Consultation Response from: KC Environmental Health (Pollution & Noise Control)

2024/92066 - Land Adj 264 Barnsley Road, Flockton, Wakefield, WF4 4AJ

Outline application for erection of dwelling

Responding Date:
17 October 2024

title site plan  
number 24065D-01-P01  
scale 1:200  
size A2

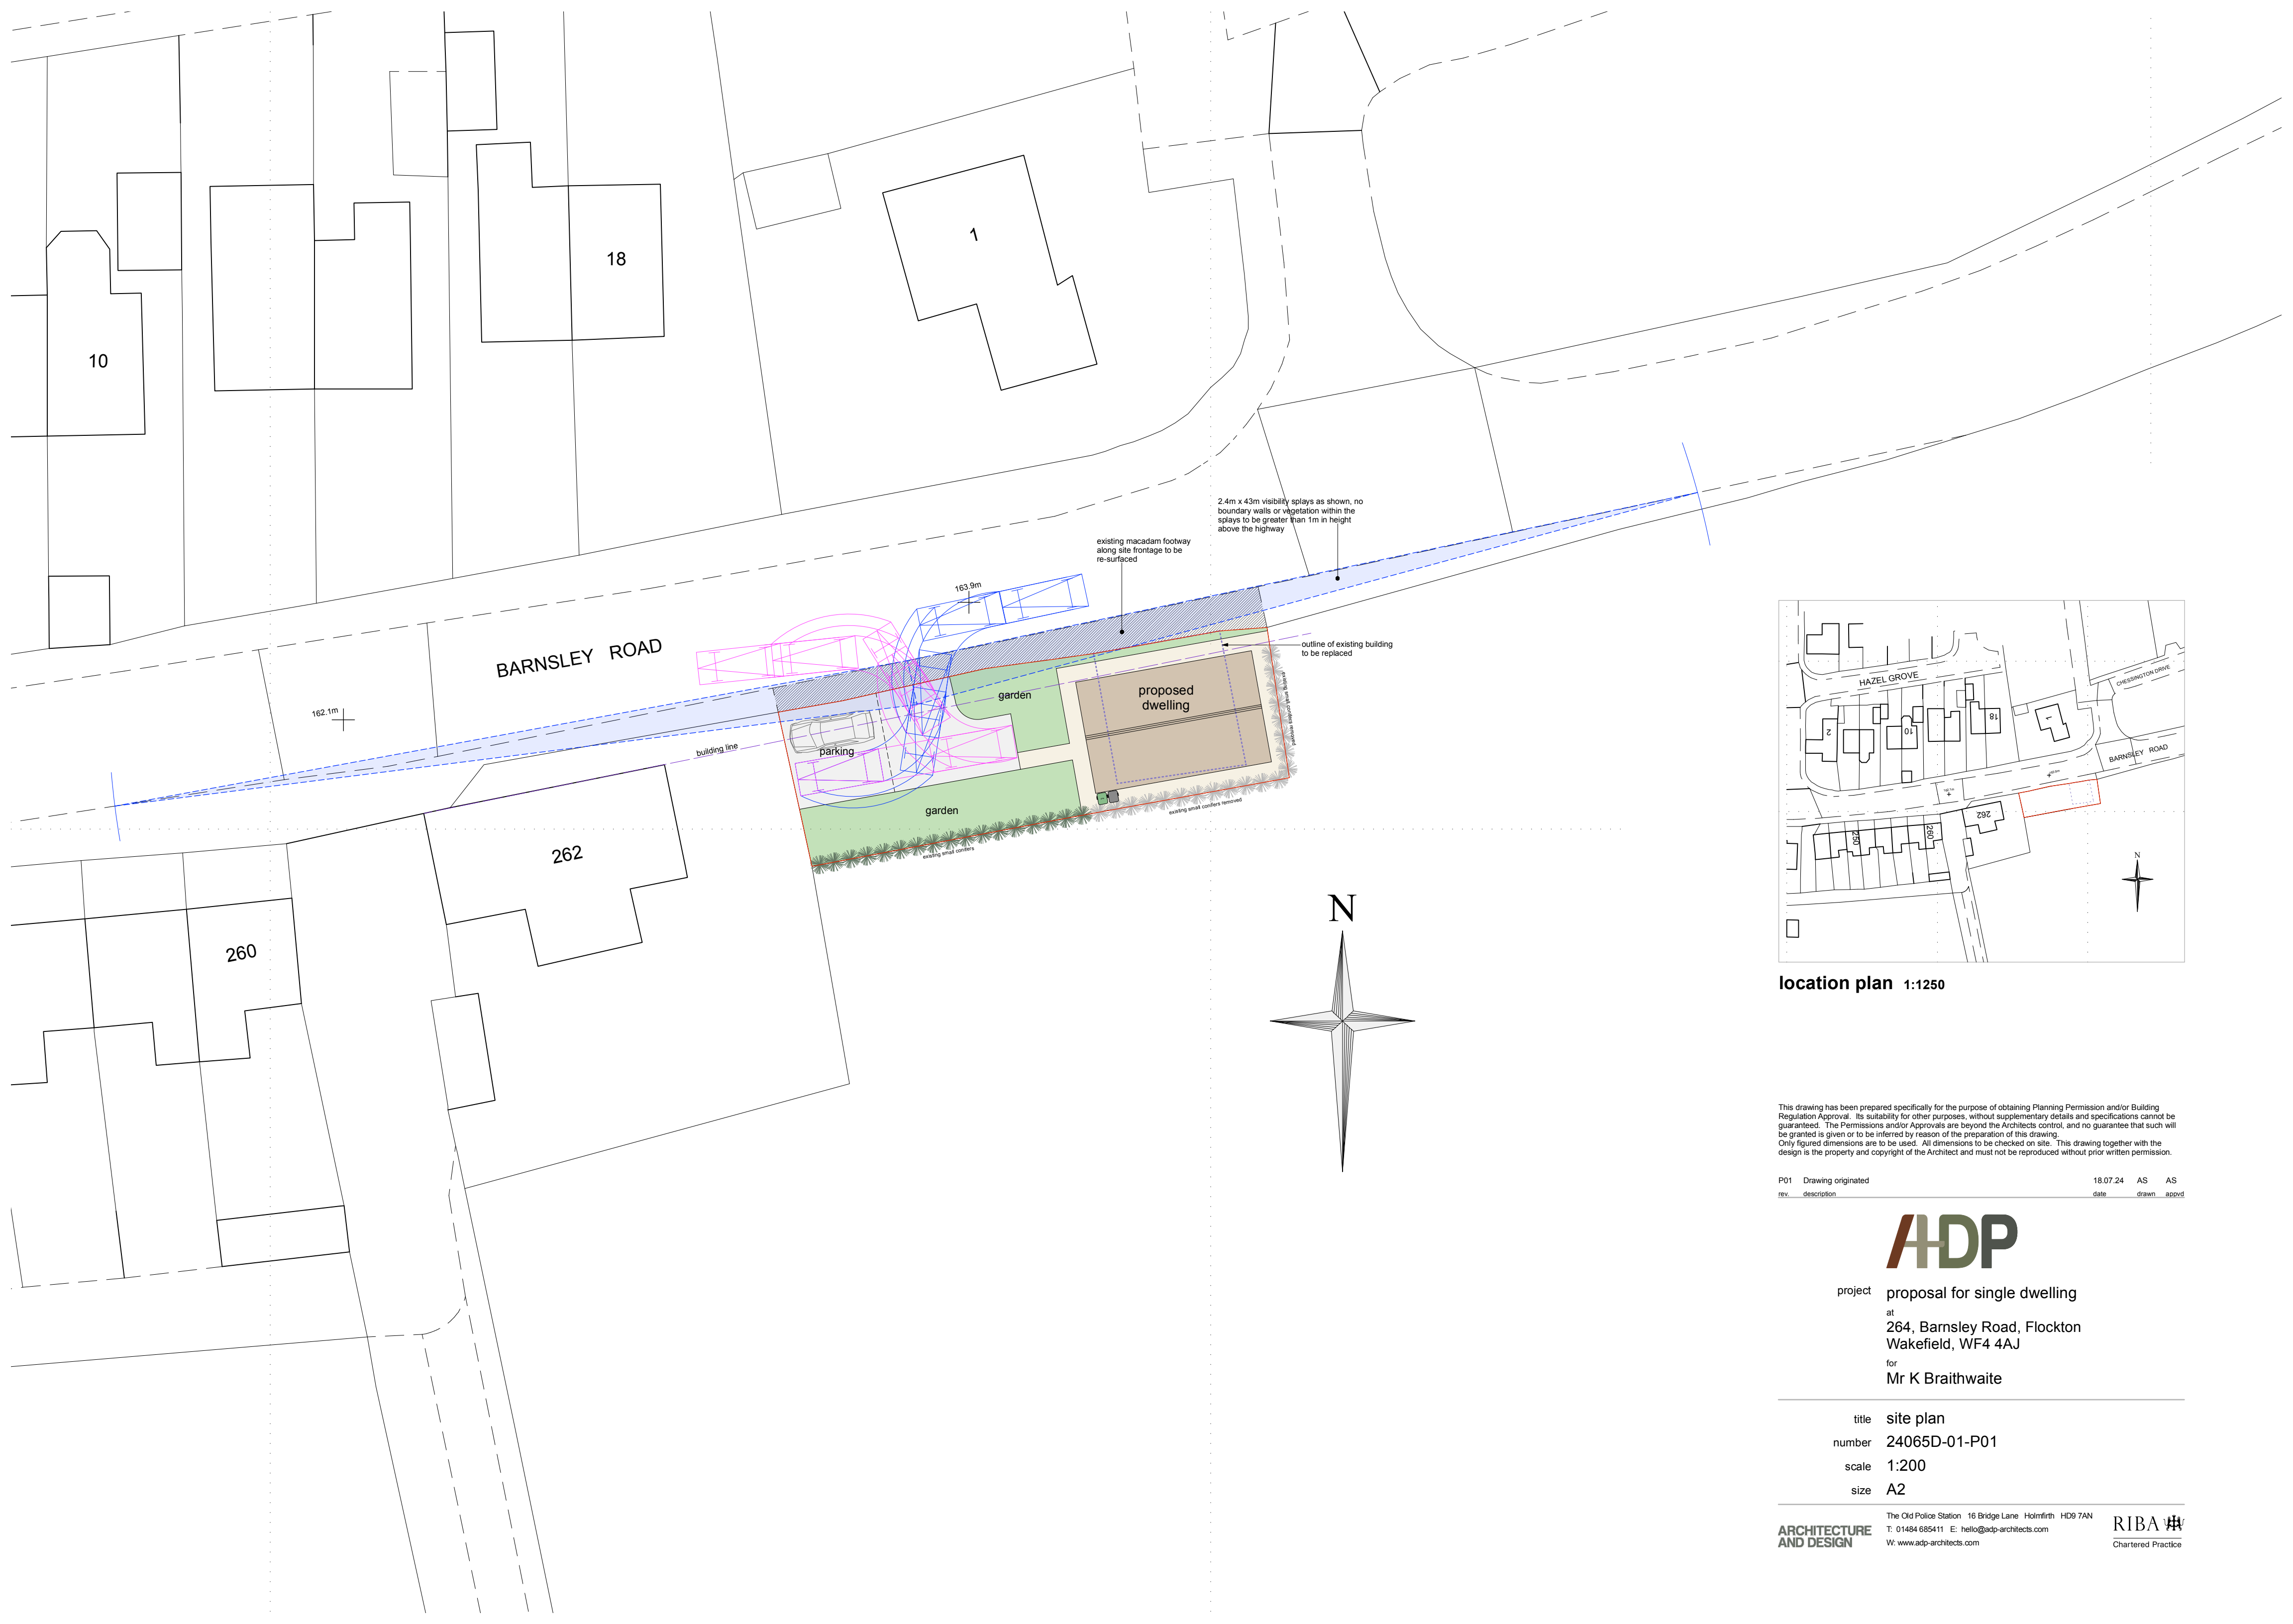
The development site sits facing the A637 which is busy road, noise from which is likely to affect the amenity of the occupiers. A condition is recommended for the submission of a noise assessment to ensure the occupiers are protected from road traffic noise.

In an application of this nature, it is expected that facilities for charging electric vehicles and other ultra-low emission vehicles are provided in accordance with the National Planning Policy Framework and *Air Quality & Emissions Technical Planning Guidance* from the West Yorkshire Low Emissions Strategy Group. The submitted site plan from ADP shows there to be two parking spaces. An advisory relating to charging points is therefore necessary.

NC9 Noise Assessment Report and Mitigation Scheme - Condition

Before construction work commences, a report specifying the measures to be taken to protect the development from noise from all significant noise sources that are likely to affect the proposed development shall be submitted to and approved in writing by the Local Planning Authority. The report shall:

- a) Determine the existing noise climate
- b) Predict the noise climate in living rooms and gardens (daytime), bedrooms (night-time) and other habitable rooms of the development
- c) Detail the proposed attenuation/design necessary to protect the amenity of the occupants of the new residences (including ventilation if required).

The development shall not be occupied until all works specified in the approved report have been carried out in full and such works shall be thereafter retained.

EVF1 Electric Vehicle Charging Points – Advisory Footnote

- Approval under the Building Regulations may also be required, and the applicant should contact their Building Control Provider for further information in relation to Approved Document S.
- The electrical supply of the final installation should allow the charging equipment to operate at full rated capacity and the installation must comply with all applicable electrical requirements in force at the time of installation.
- To futureproof the development, we would encourage the applicant to provide these in accordance with the current *Air Quality & Emissions Technical Planning Guidance* from the West Yorkshire Low Emissions Strategy (WYLES) Group
